PARRAMATTA POWERHOUSE (SSD-10416)

**Submission to Applicant's 'Response to
Submissions' made on behalf of the
landowners of 32 Phillip Street, Parramatta**

This submission has been prepared by Urbis Pty Ltd on behalf of the landowners Australian Unity Office Fund (**Australian Unity**) of 32 Phillip Street, Parramatta (**subject site**) in response to Powerhouse Parramatta application's (SSD-10416) (**Powerhouse SSDA**) **Response to Submissions (RTS)**, dated 8th October 2020.

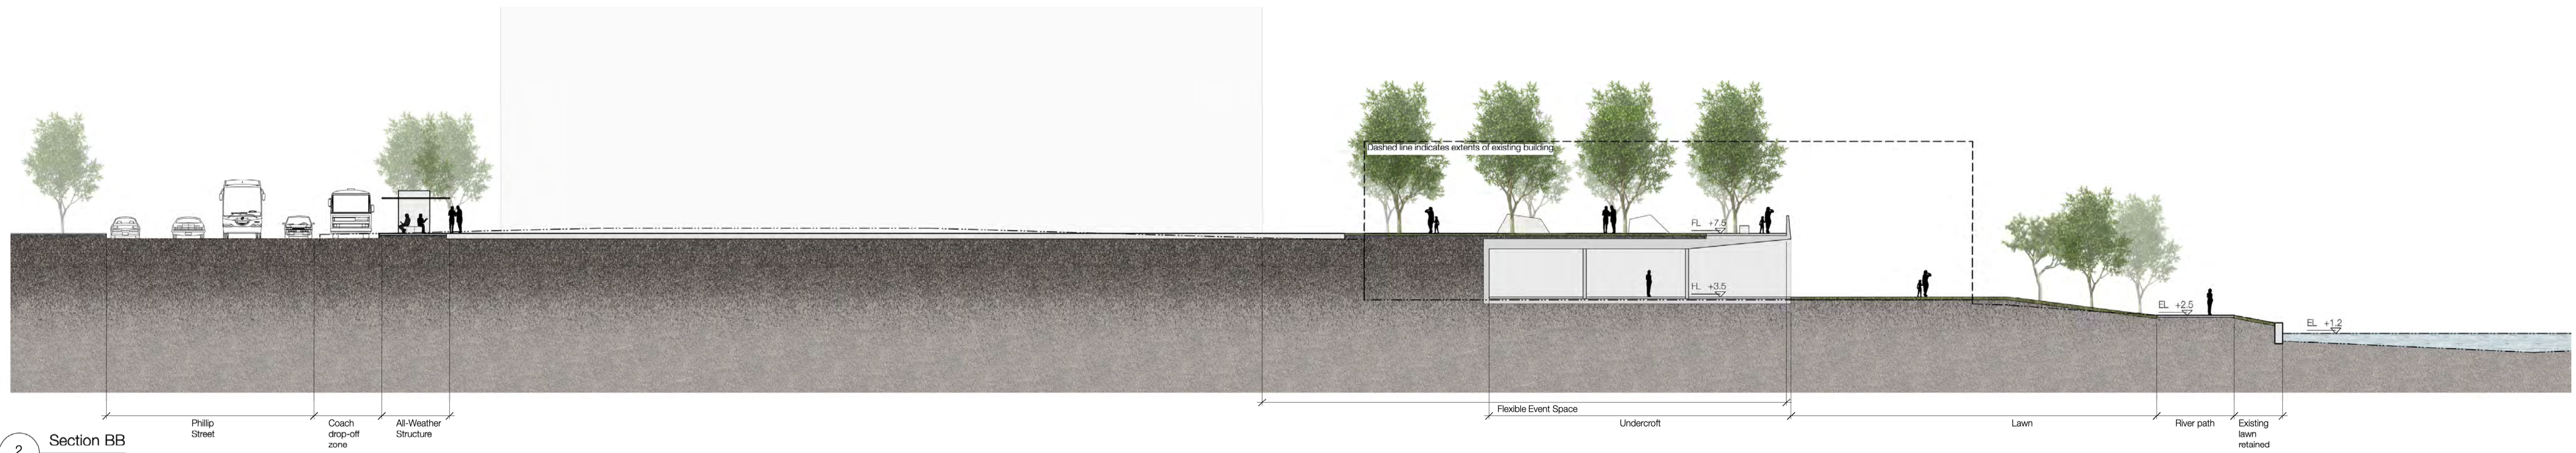
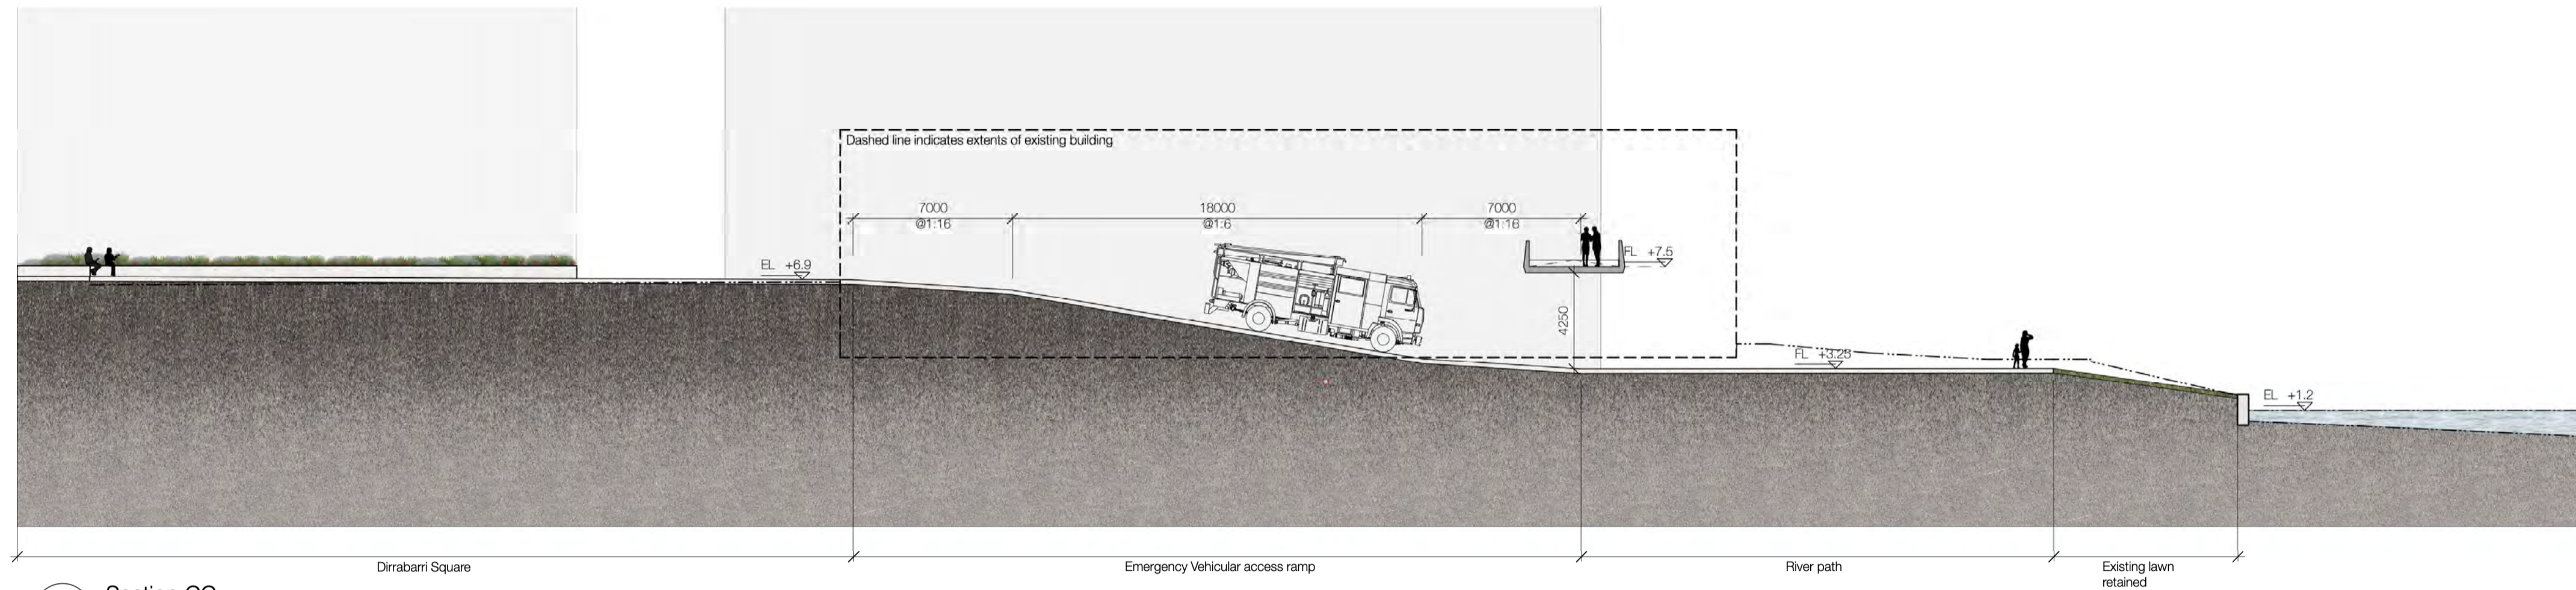
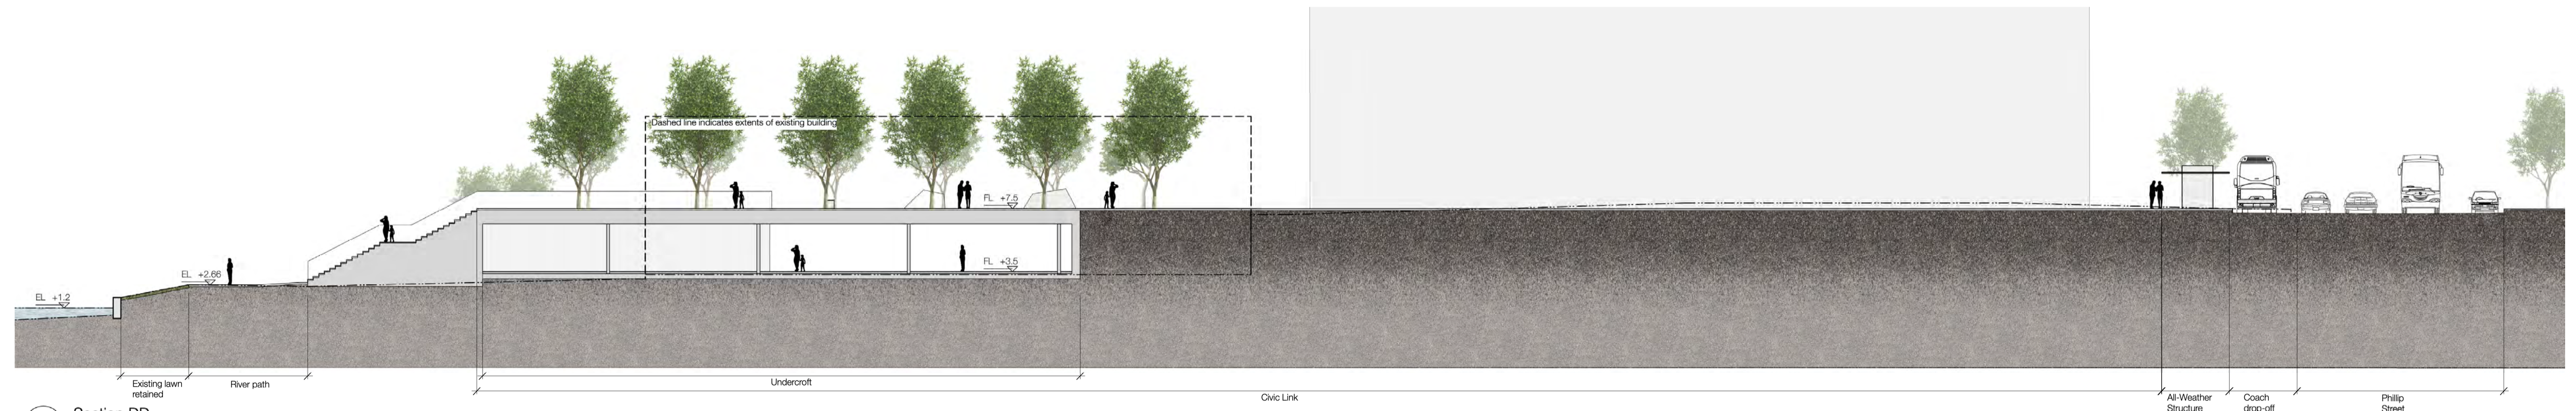
Despite widening of the Civic Link as a result of changes to PPM building envelopes, the PPM RTS seeks to provide continuous landscaping to the western frontage of the Civic Link, surrounding the boundary of 32 Phillip Street.

1a) The PPM project team should be requested to refine the proposed landscape treatment for the Civic Link and meet with Australian Unity to discuss appropriate landscape treatment adjoining the boundary with 32 Phillip Street

1b) The landscape treatment on the western side of the Civic Link should allow for ground level use of the 32 Phillip Street site (existing and future) to include active uses that address and make the most positive contribution to activating the Civic Link.

1c) The landscape treatment of the Civic Link should be open to allow pedestrian movement and visual connections between buildings on both sides of the Civic Link.

1d) The landscape solution for the PPM should provide for outdoor dining opportunities including licenced areas along the western edge of the Civic Link fronting the 32 Phillip Street site.
